Subject: RE: Planning Consultation on FP/42/19/DOC

Engineers Comments Regarding Condition 7

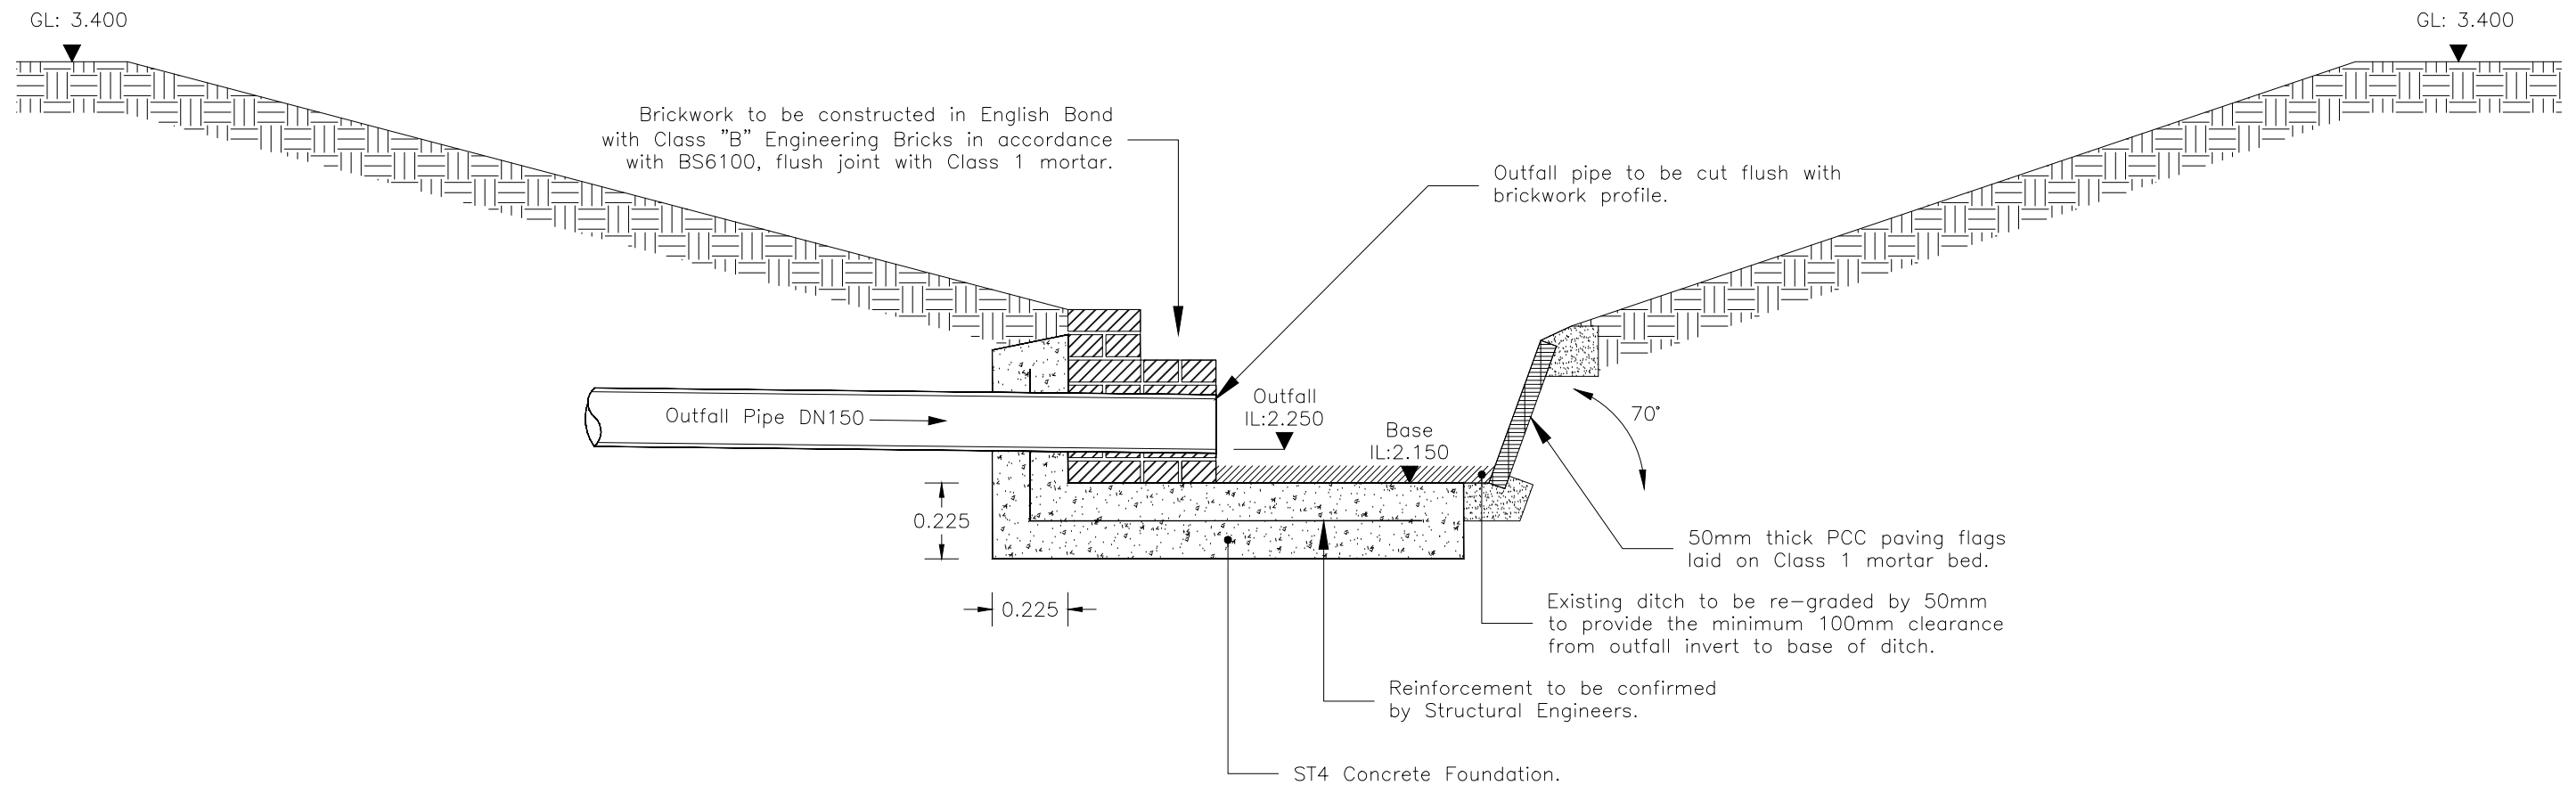
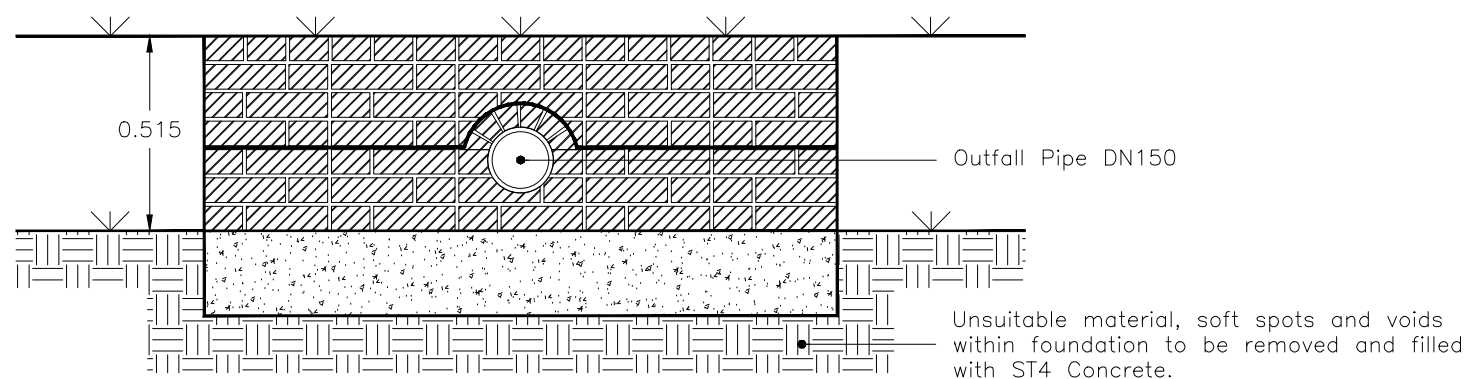
2. No construction detail drawings have been provided. Please provide construction detail drawings of manholes, catchpits, permeable paving, attenuation tank and hydrobrake.
Please refer to the following drawings:

- 5782:20 Outfall Details
 - 5782:21 Adoptable Drainage Details
 - 5782:22 Private Drainage Details
 - 5782:23 Construction DetailsThe above layouts demonstrate the required details.

Project: Wellers Close Hampshire Homes Group	
Drawing: Soft Landscaping Concept	
Date: May 2018	Drawn by: JA
Scale: 1:200 @ A1	Revision: -

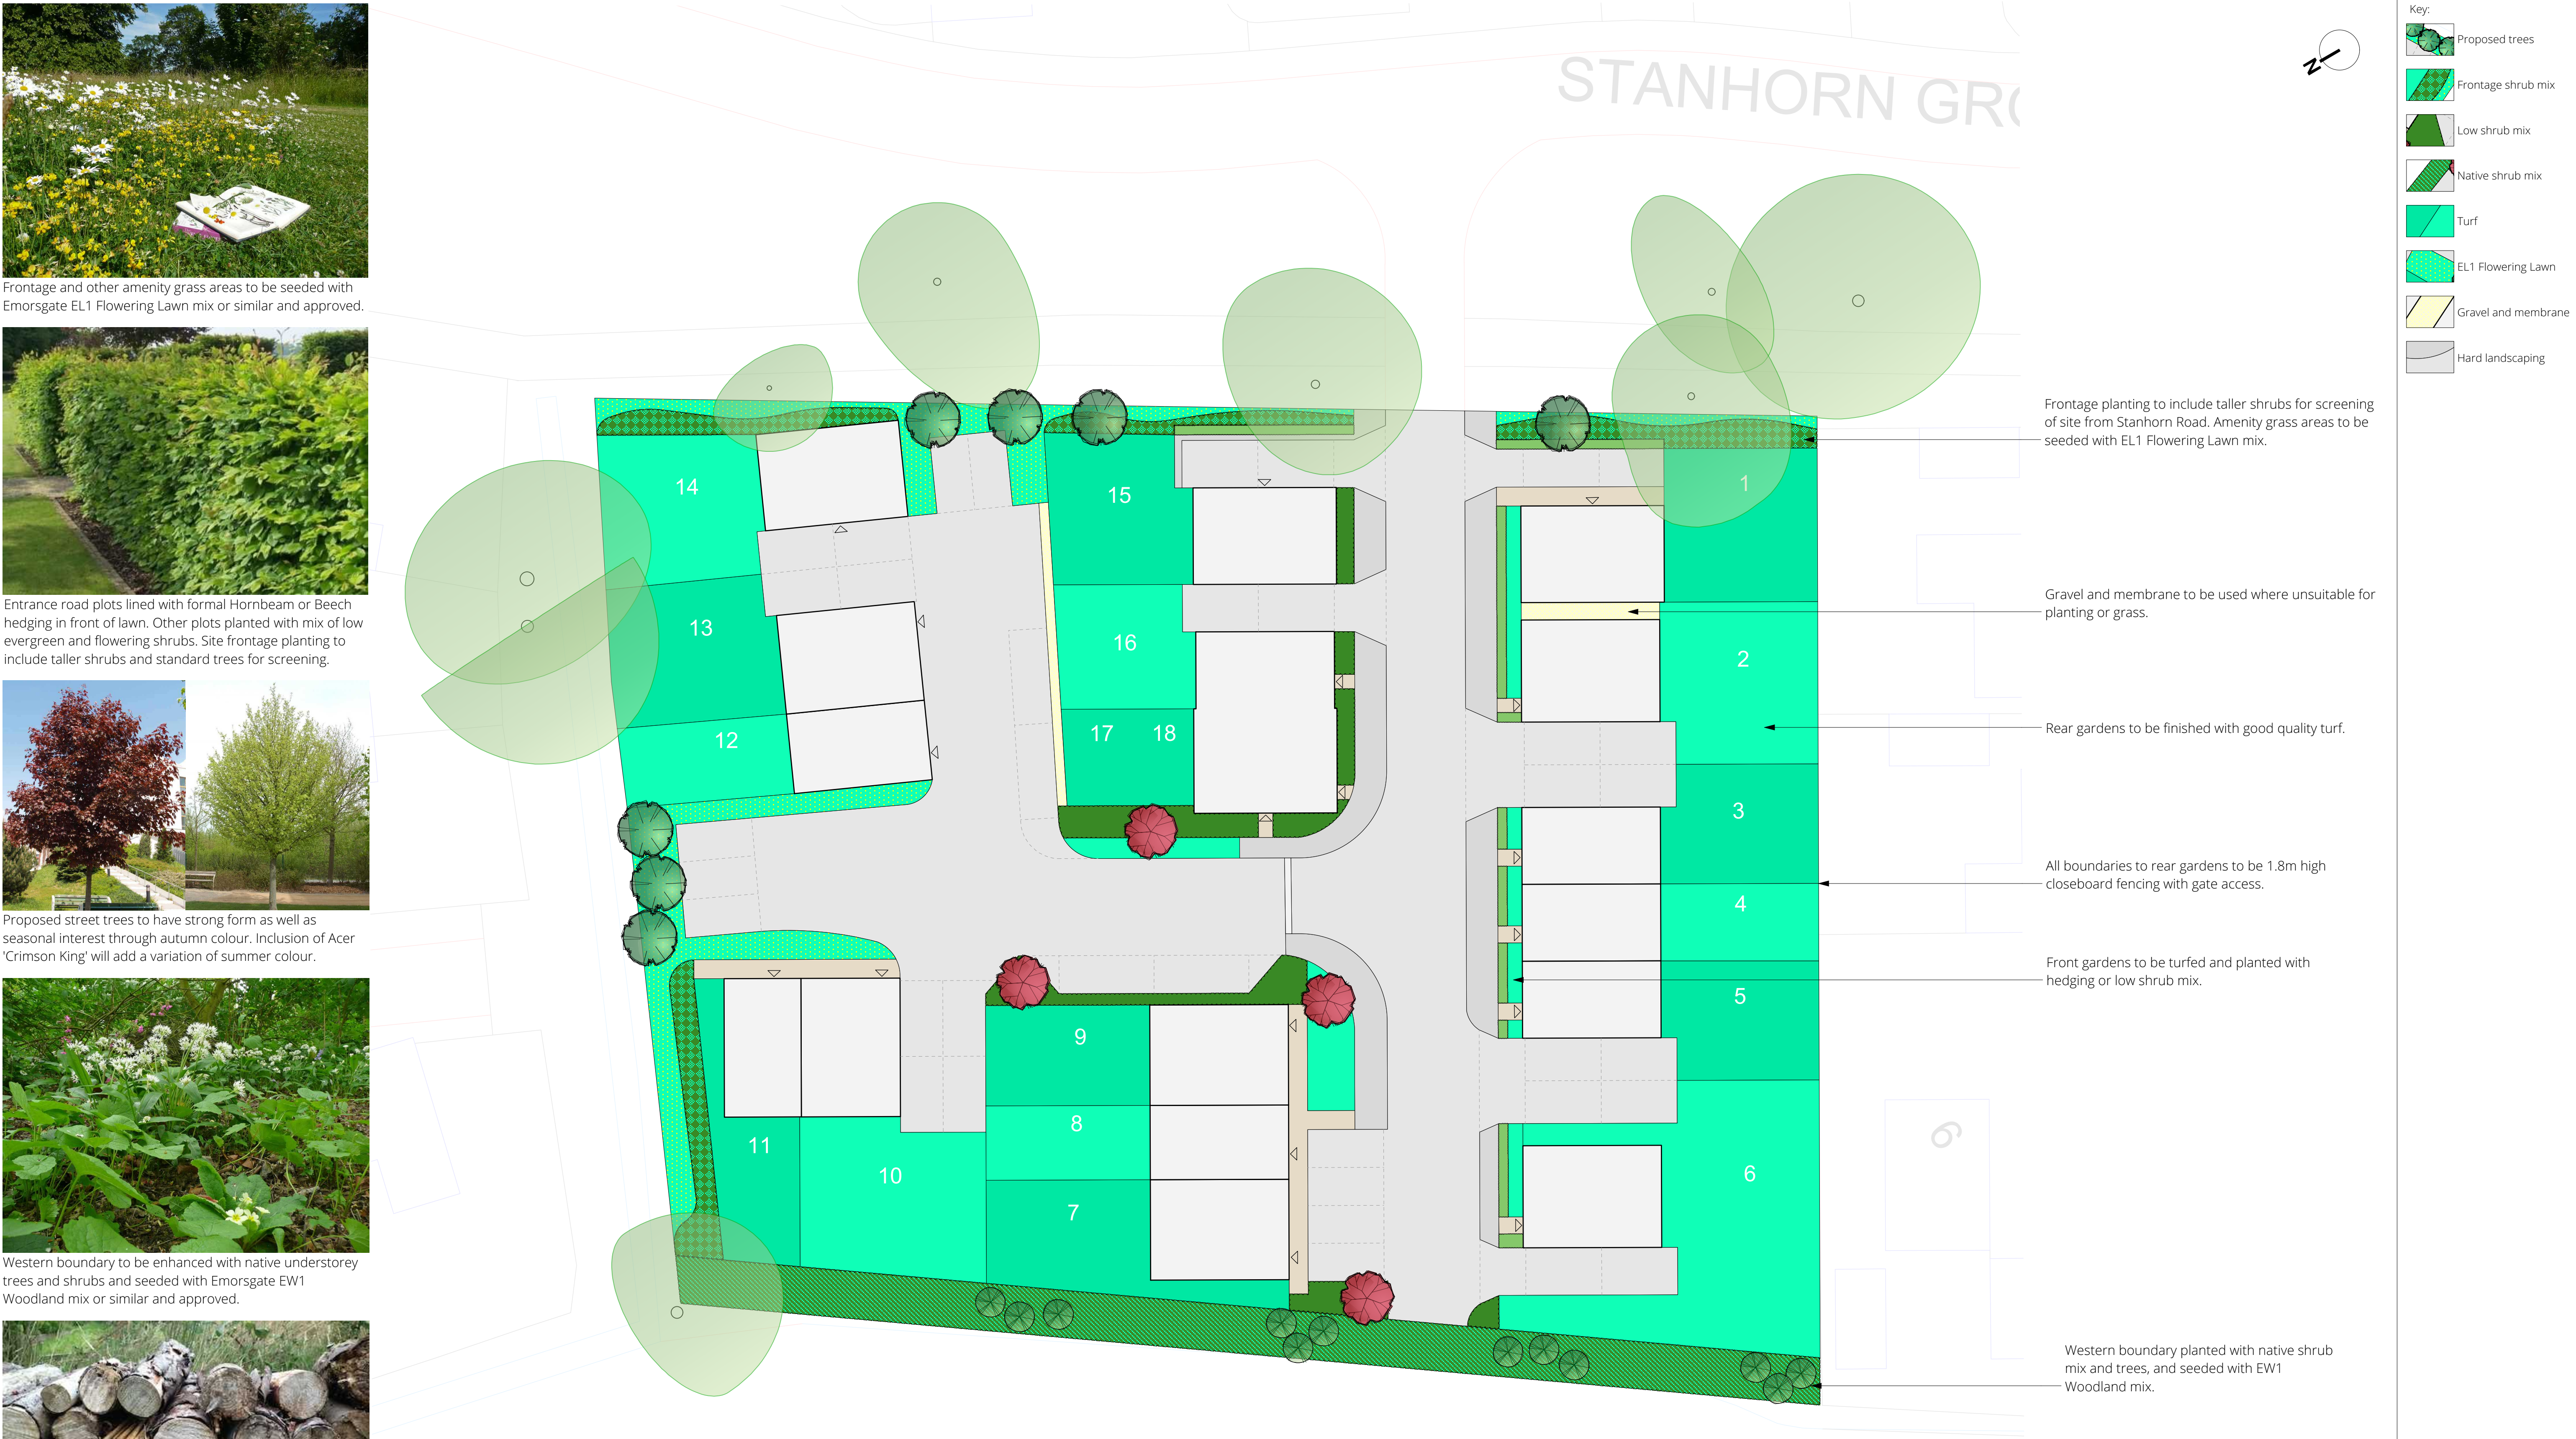
3. There is conflict between the landscaping proposals and the drainage proposals. Trees must not be located on or near attenuation tanks. Please revise the landscaping proposals.
Consideration has been made, nevertheless the proposed attenuation tank is located within the carriageway. A note has been added to our engineering layout stating no trees should be planted within close proximity of to the proposed attenuation tank.

Rev.	Date	Note	Author	Checked
A	11/06/19	De-mountable fence indicated to rear of Plots 12 - 14	RR	JP

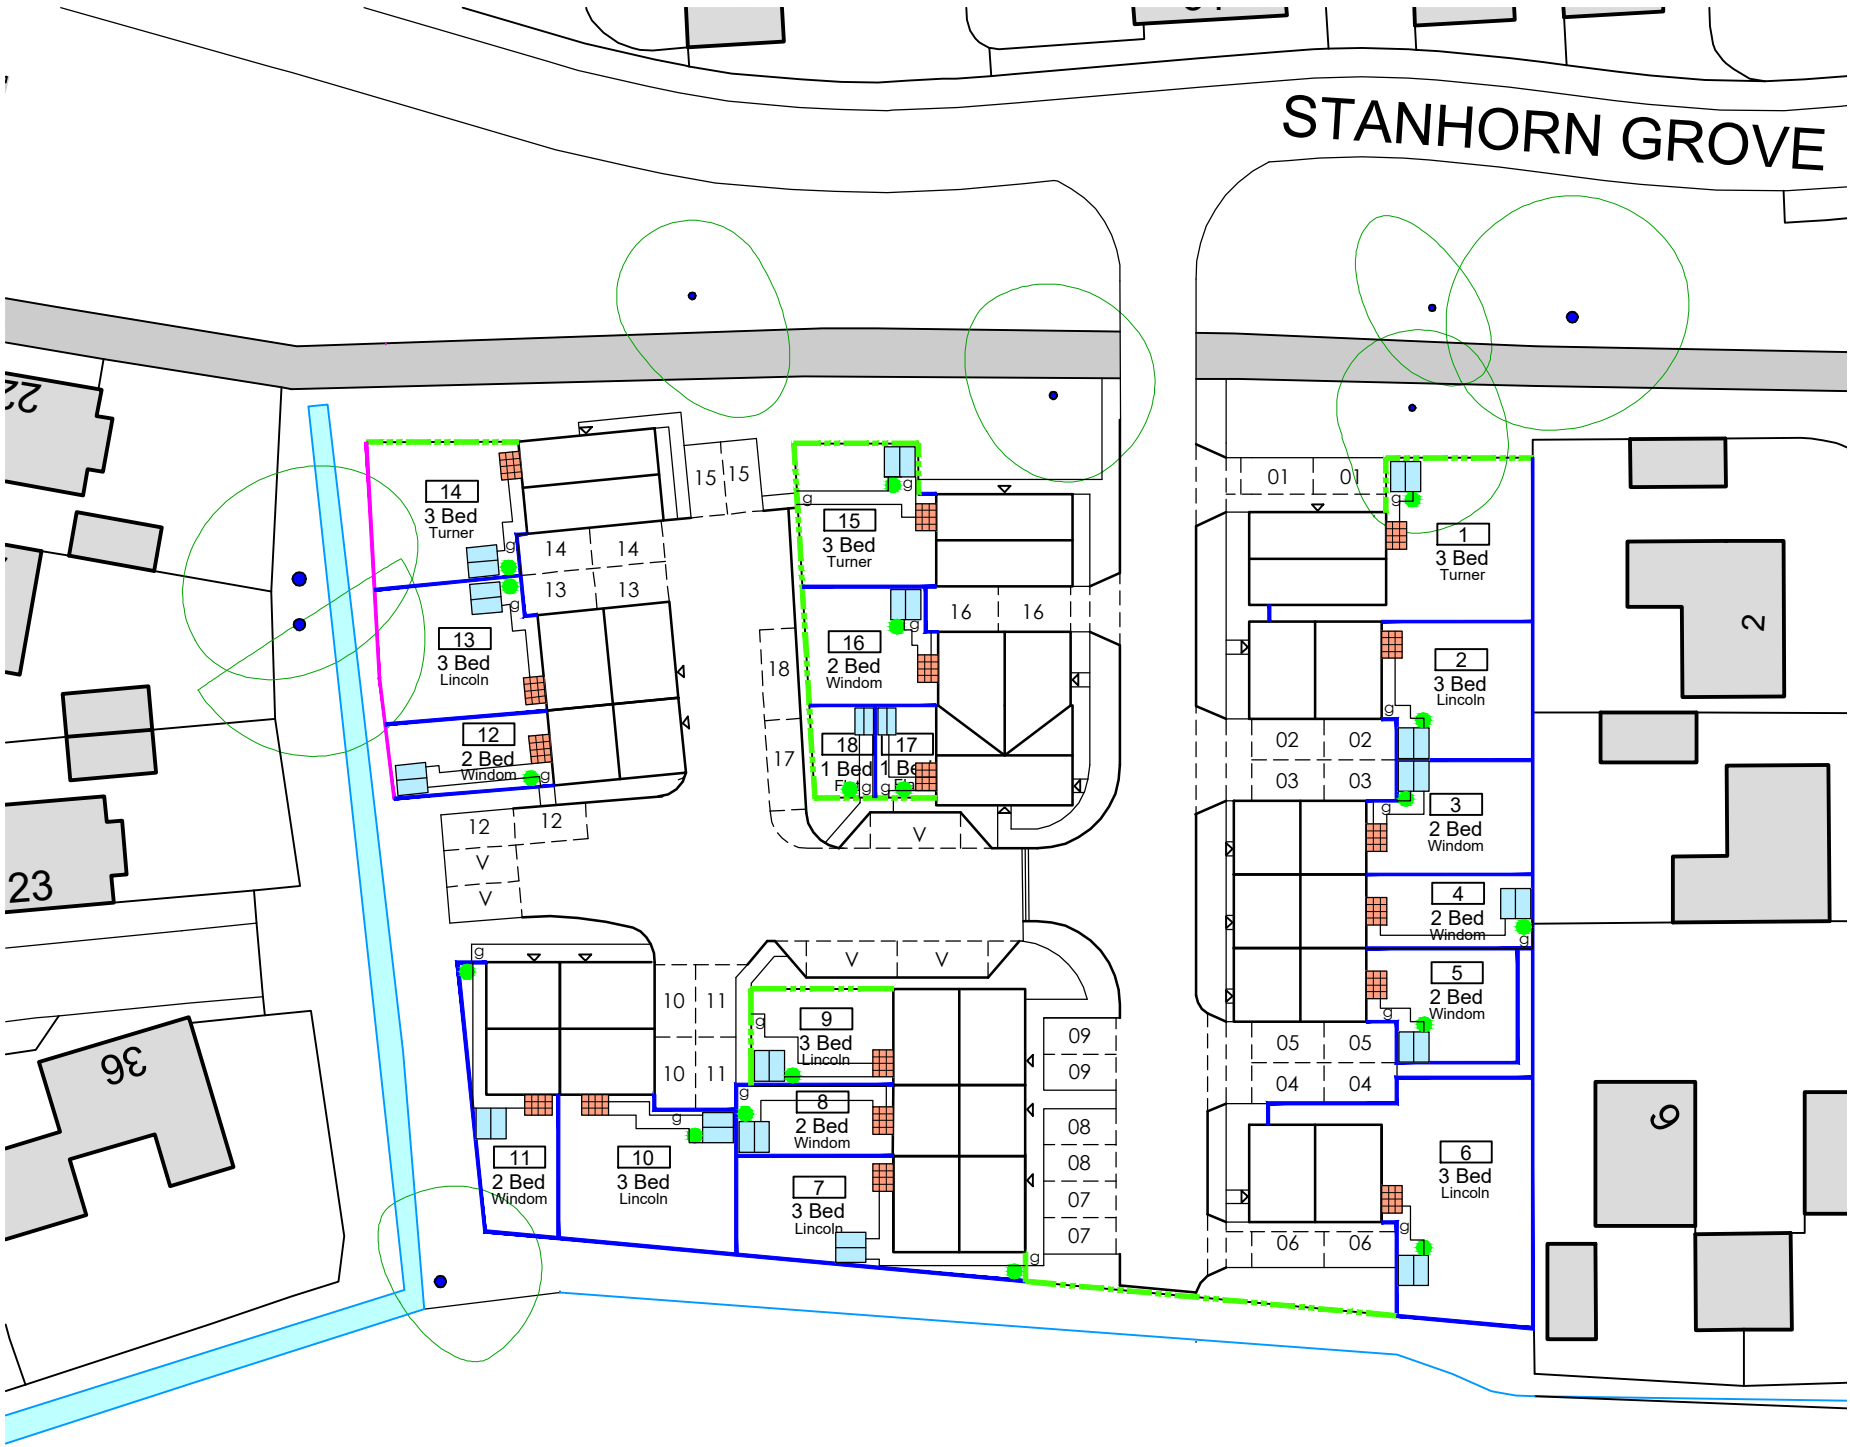
Proposed property boundaries for plots 12-14 need to be amended to allow access to the watercourse. 3m easement is required from any building, fence or wall and the top of bank of an ordinary watercourse.

In regards to the easement location between the two fences there is a 12m gap, the adjacent properties backing onto the ditch have a hard boundary onto the bank whereas we do have the majority buffer.
